NAME: **ROBERT SUTTON**

APPLICANT: NSW DEPARTMENT OF EDUCATION.

APPLICATION NUMBER: SSD-10465

STATEMENT OF NIL SUPPORT: **OBJECTION.**

4 Winter Solstice - 10am Proposed

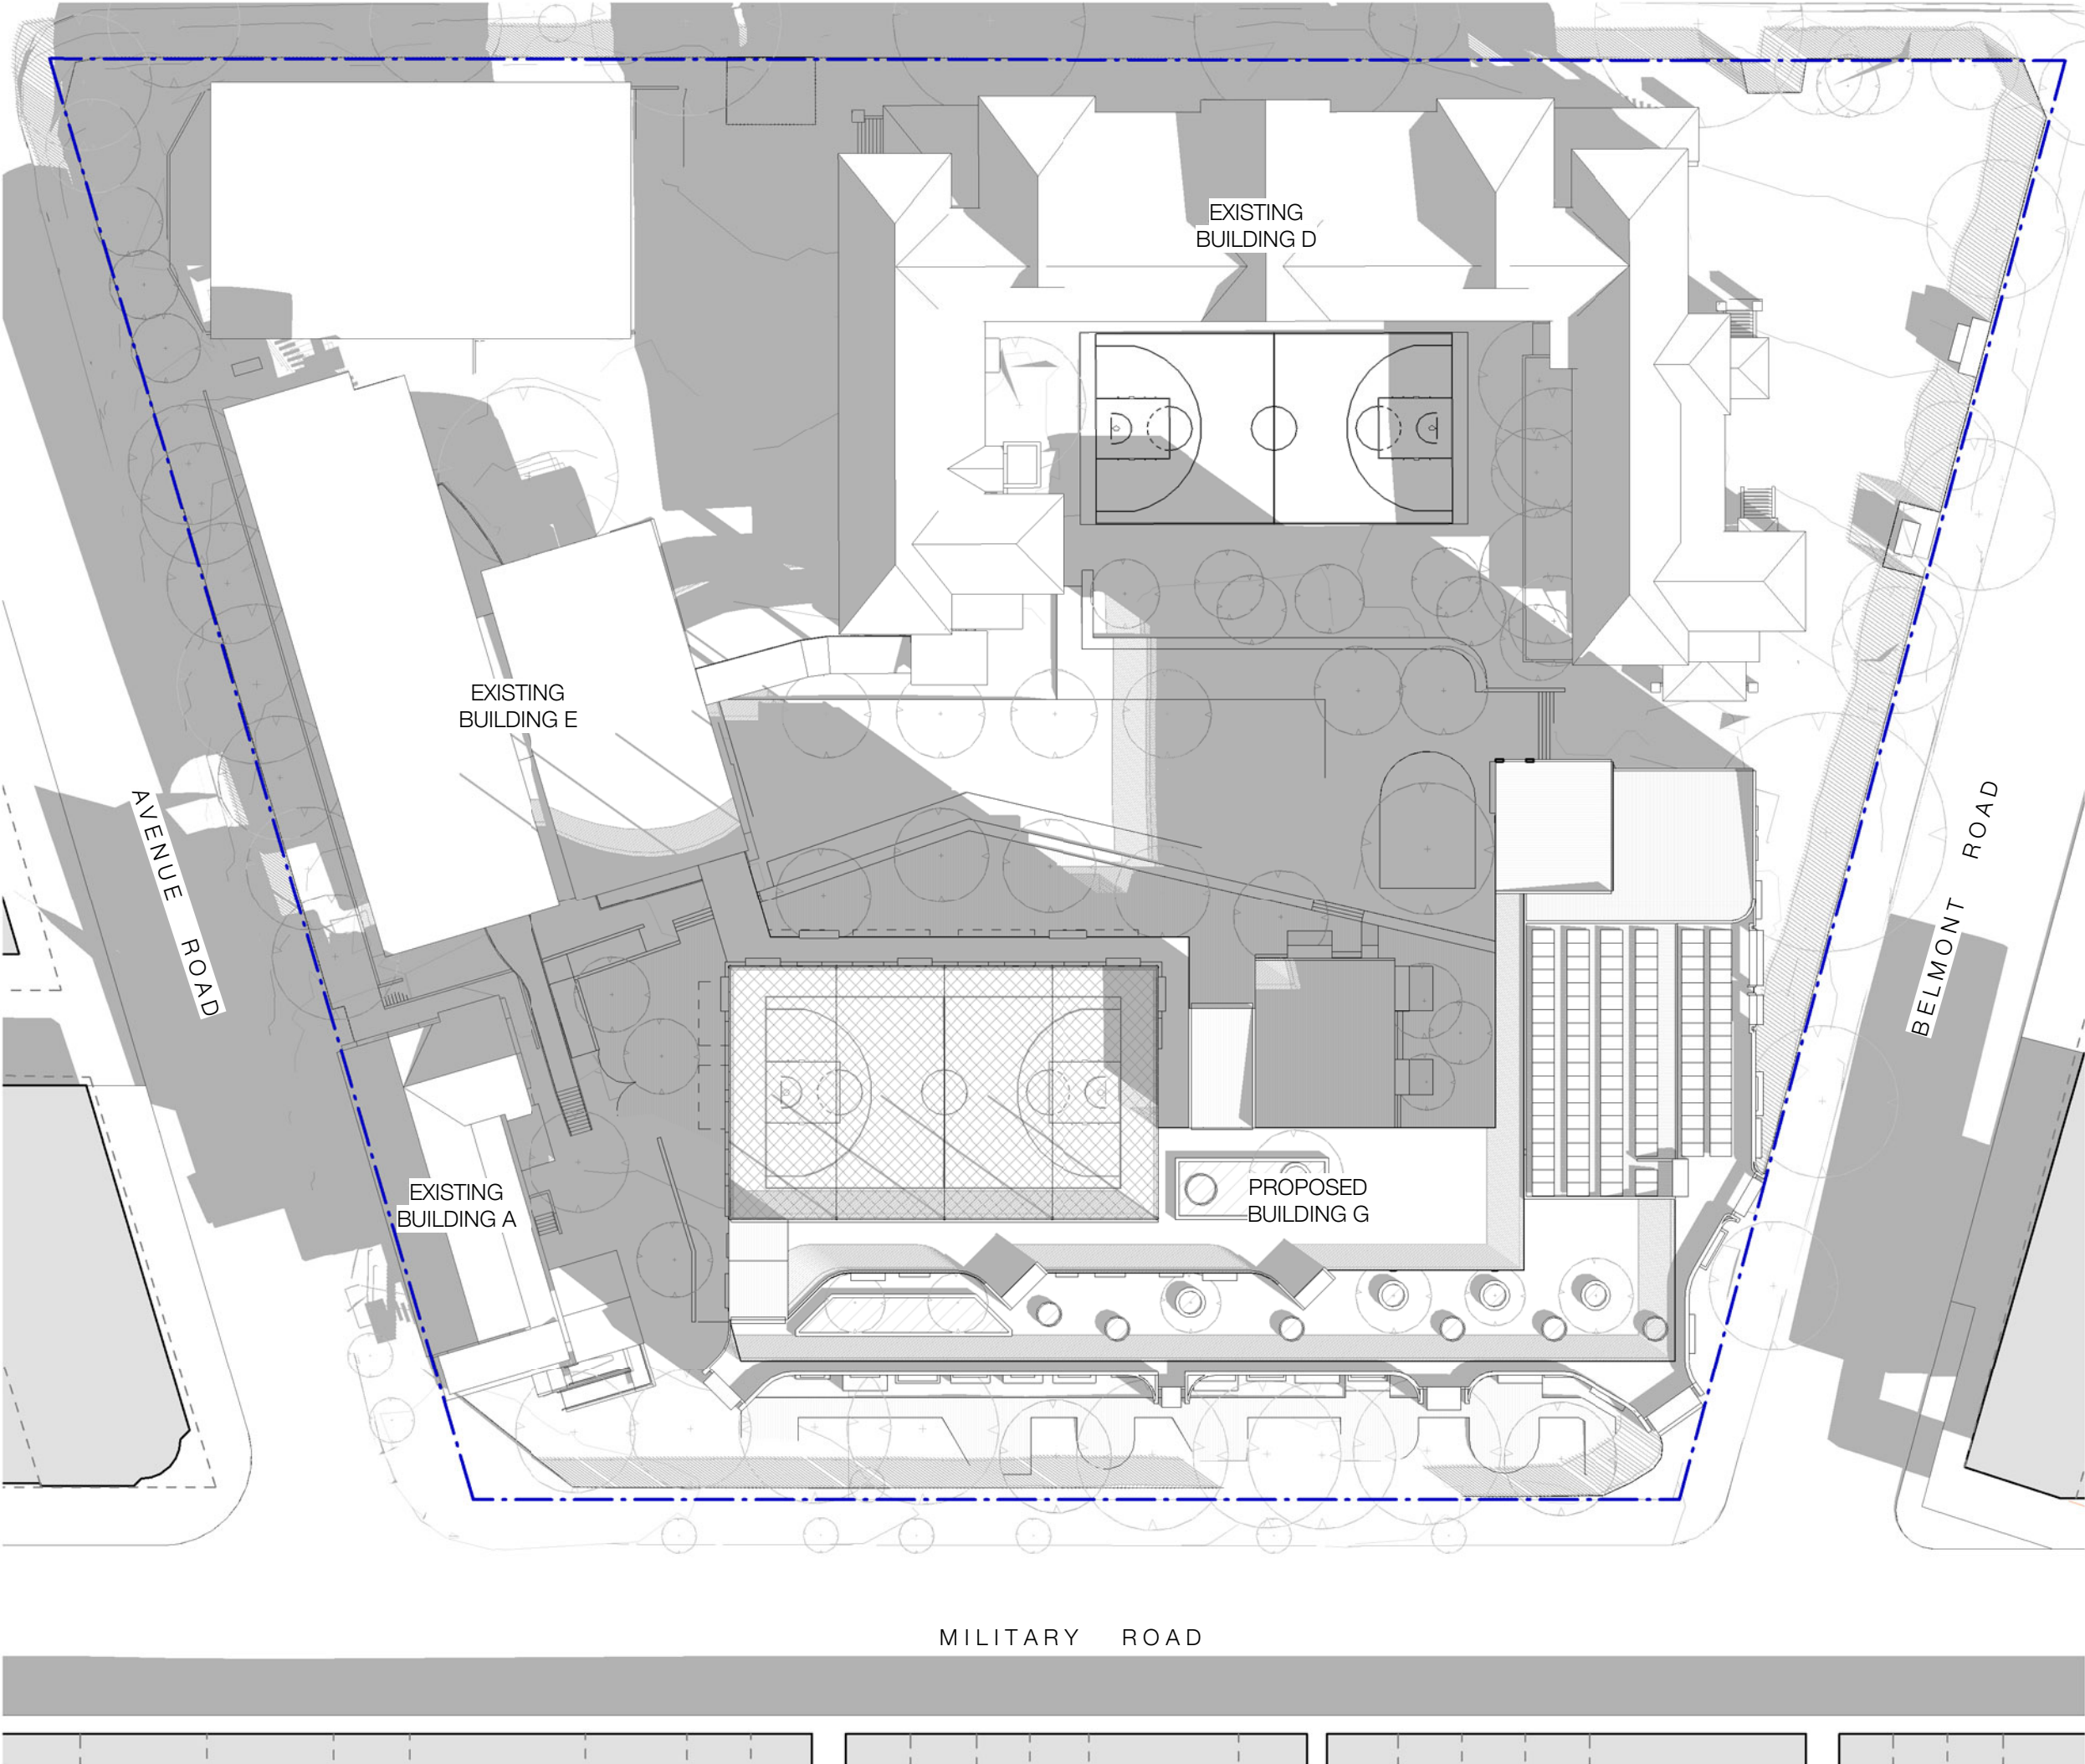
4. WOOD BAGOT SITE PLAN (SSD-1104 Rev2).
We note that plans submitted for public comment are only PRELIMINARY. This is unacceptable as they are technically incomplete and do not reflect the actual site complete shadow diagrams. Evidenced by the missing presentation of FULL SHADOW DIAGRAMS on impacted (Morning) Belmont Road, Keston Avenue & Avenue Road e.g. South West corner 6:00am(Summer) to 7:30am(Winter). Let's be honest – Easterly morning sun shine is critical to our neighbours amenity. (Afternoon) – Military Road retail shopping strip (Winter) 3:00 - 5:00pm. Let's keep the retail street sunny and a great place to shop.

Sheet number SSD-2203	Revision 2
Status PRELIMINARY

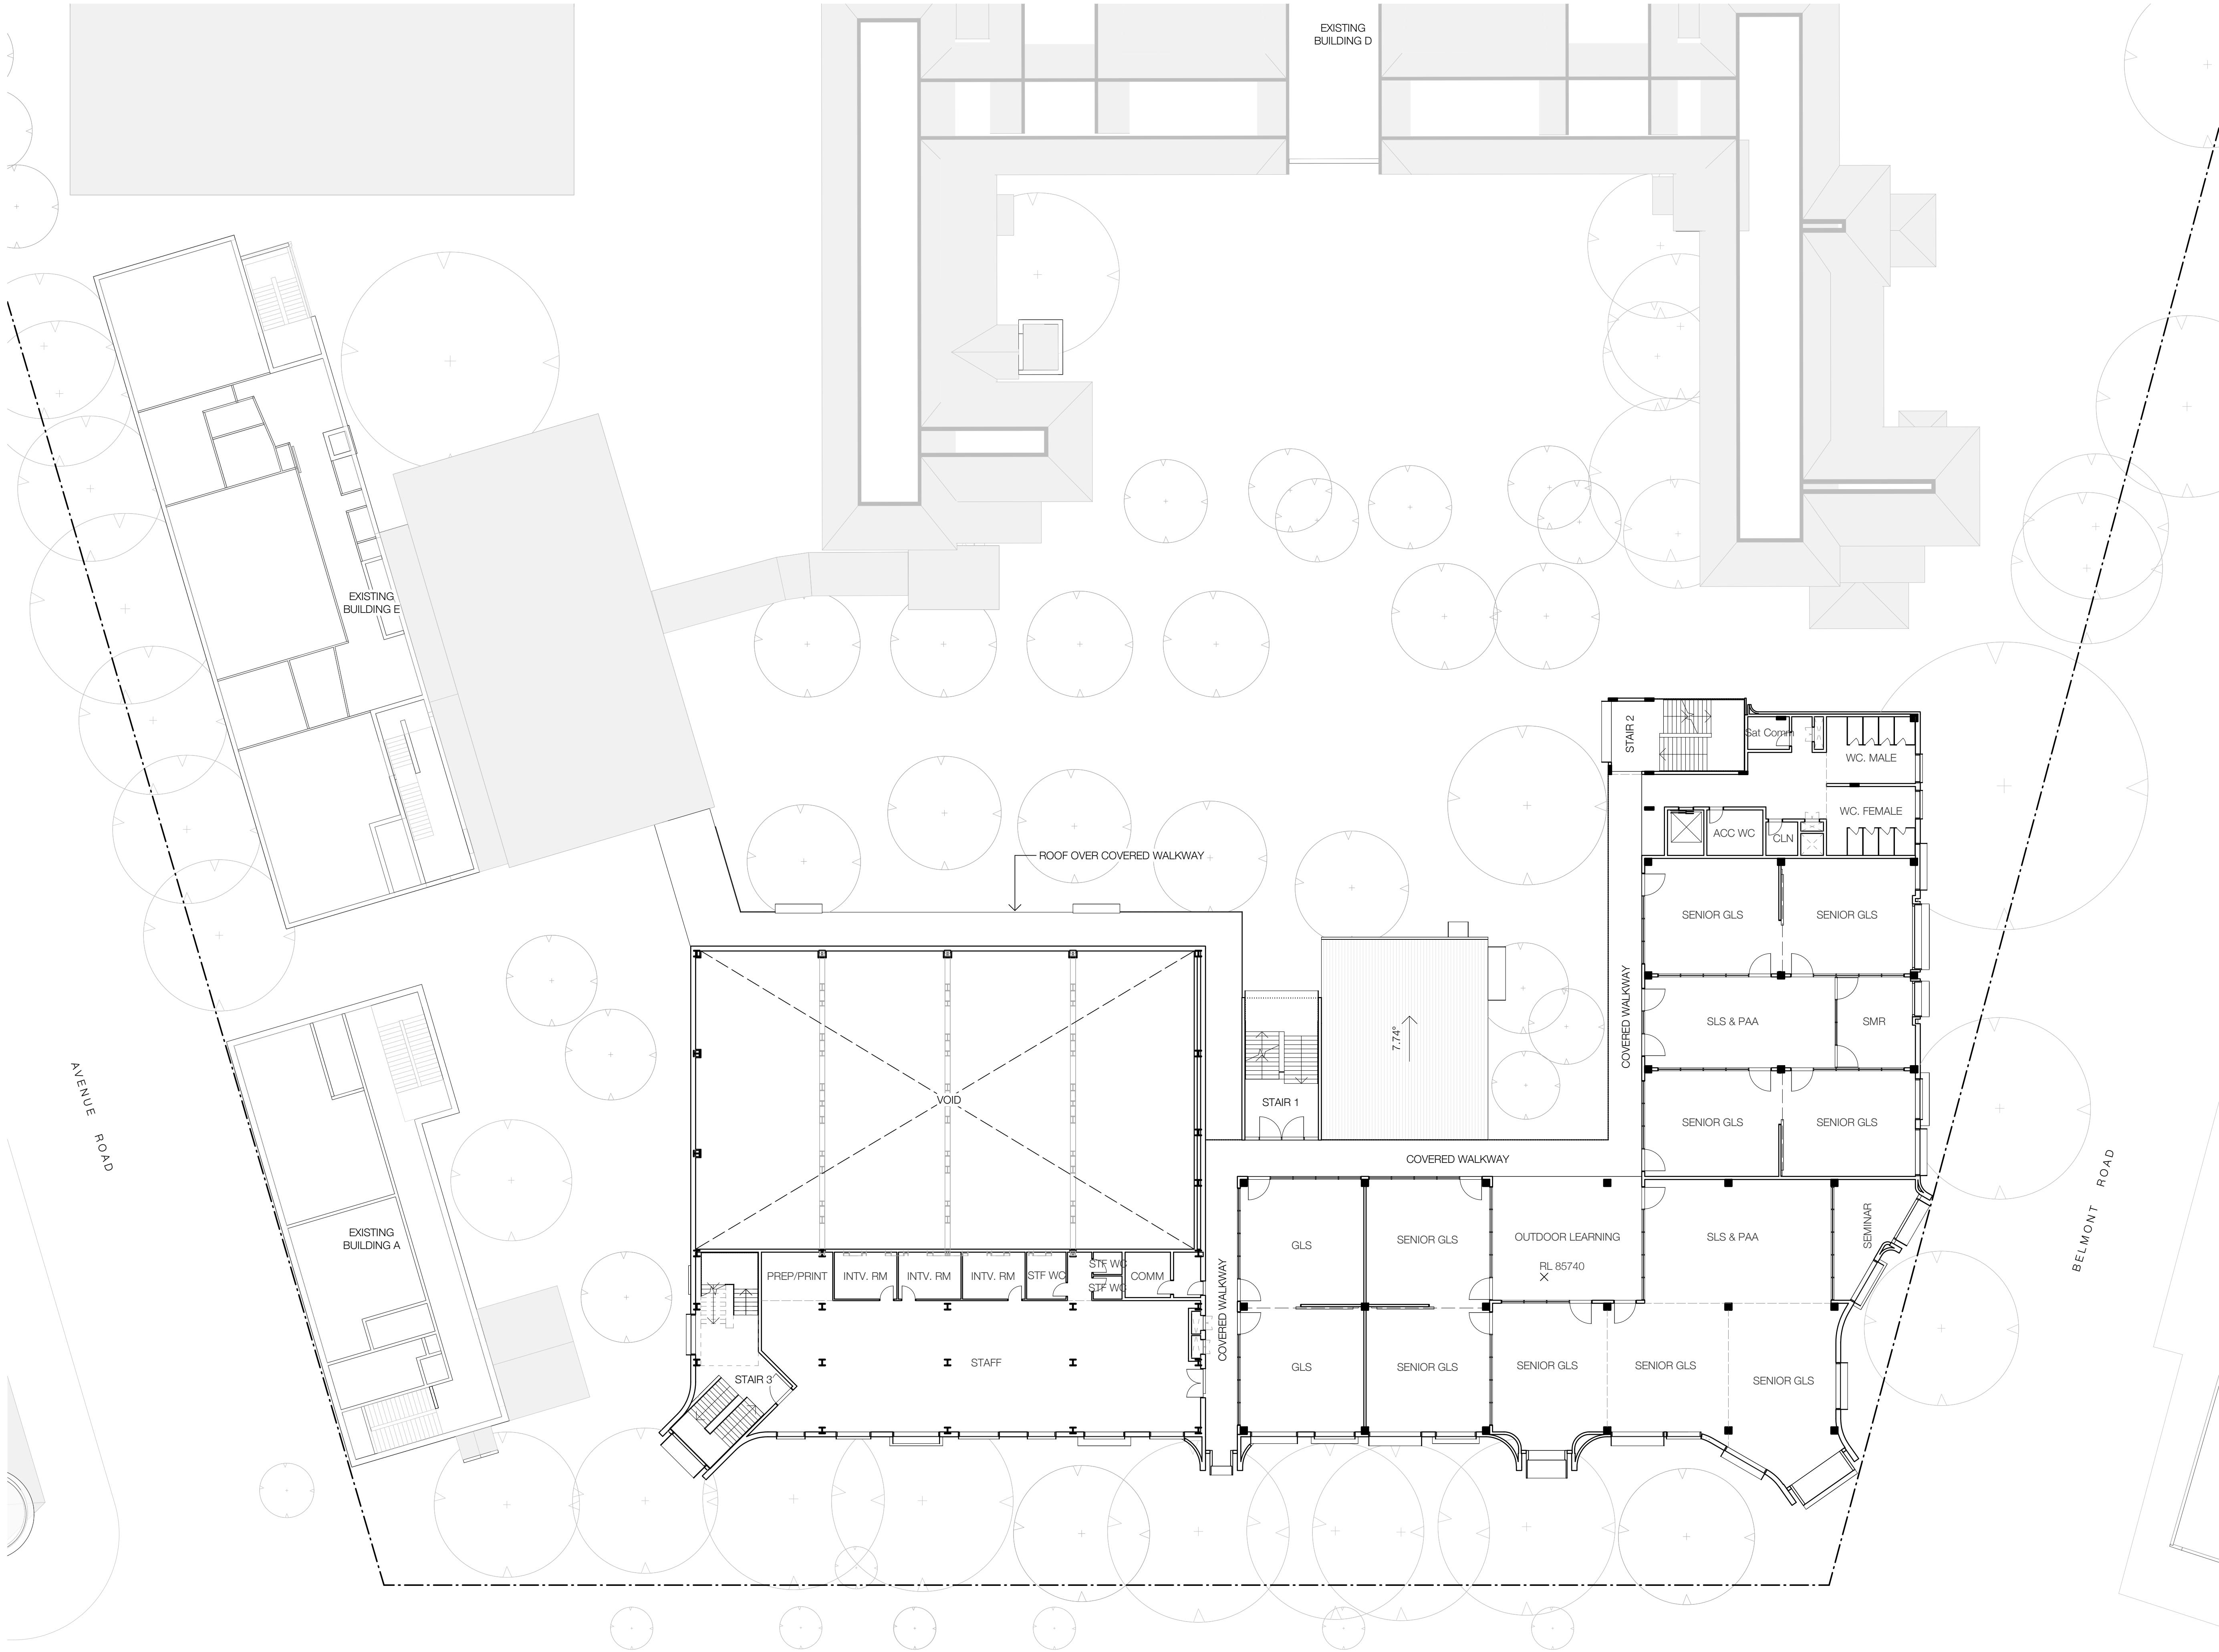
These PRELIMINARY proposed plans are faulty. Evidence: Plans don't even make sense e.g. SSD-2203(Rev2) North East Corner Seminar Room. Clearly no necessary business case has been established for a room without doors.

Sheet number	Revision
SSD-5202	2
Status	
PRELIMINARY

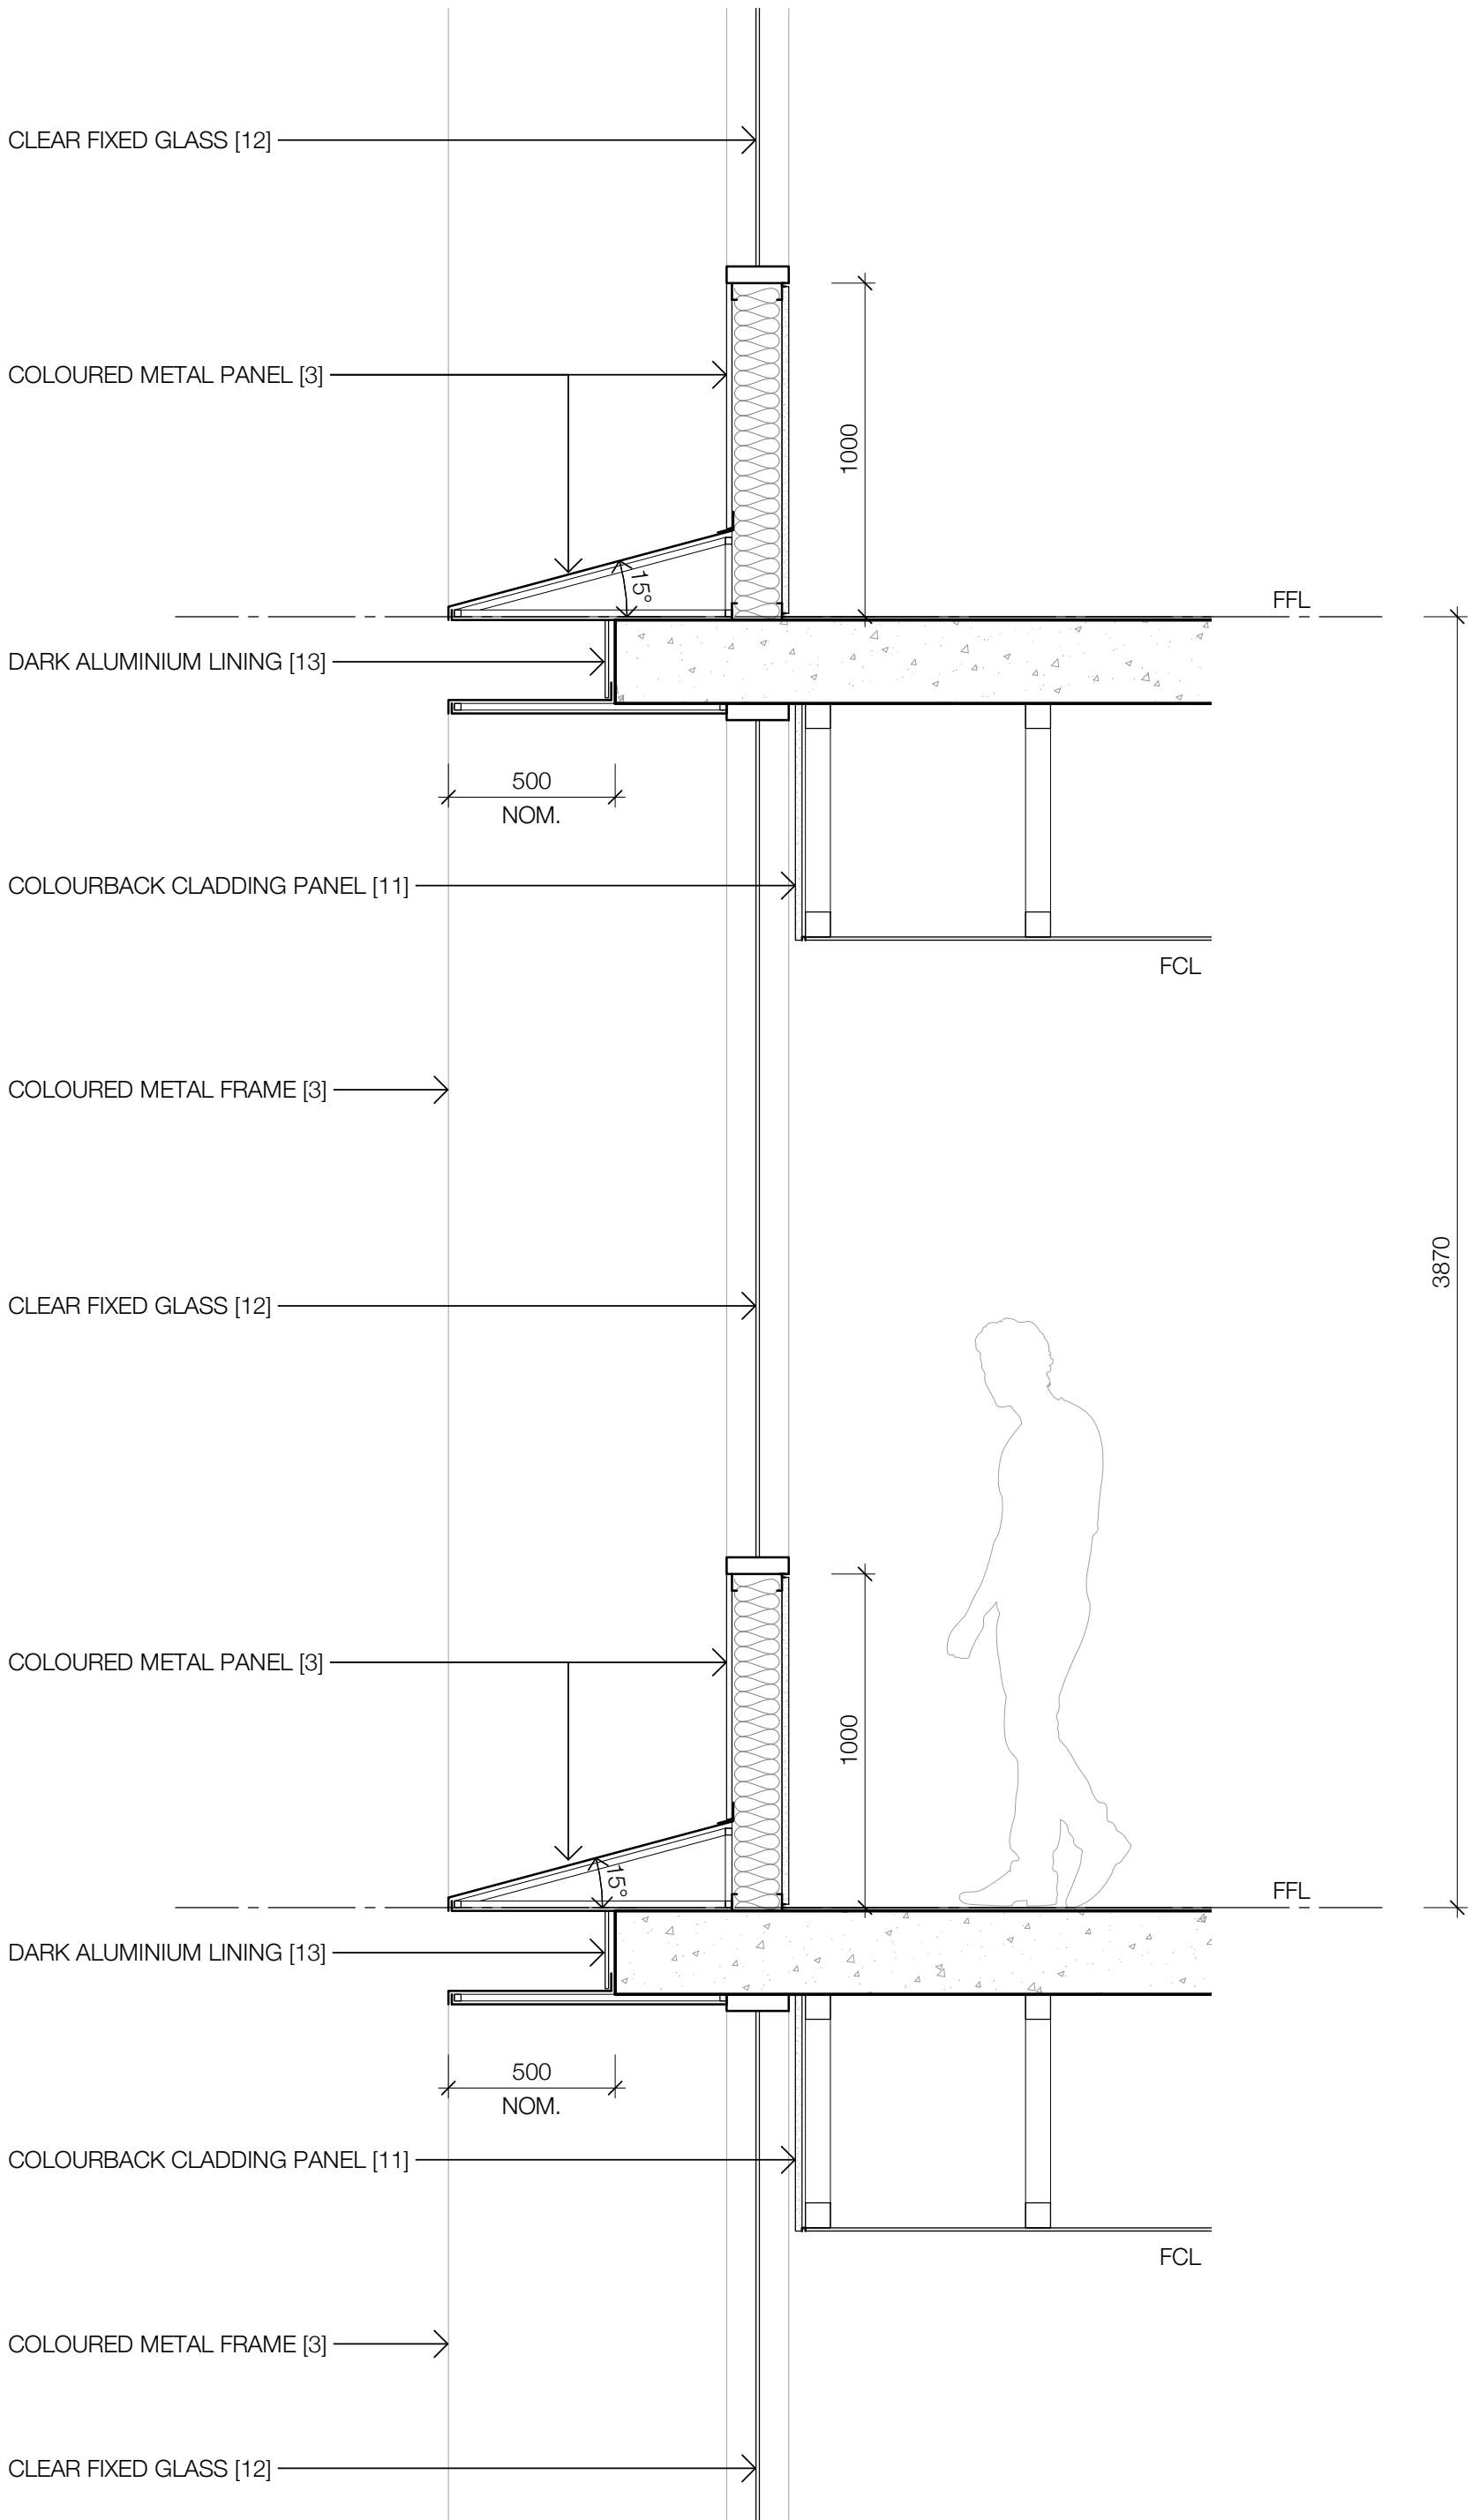
10. FACADE – SSD-5202(Rev2). Views into school rooms are not a community improvement. Probably a security risk as well. Images do not reflect plans.
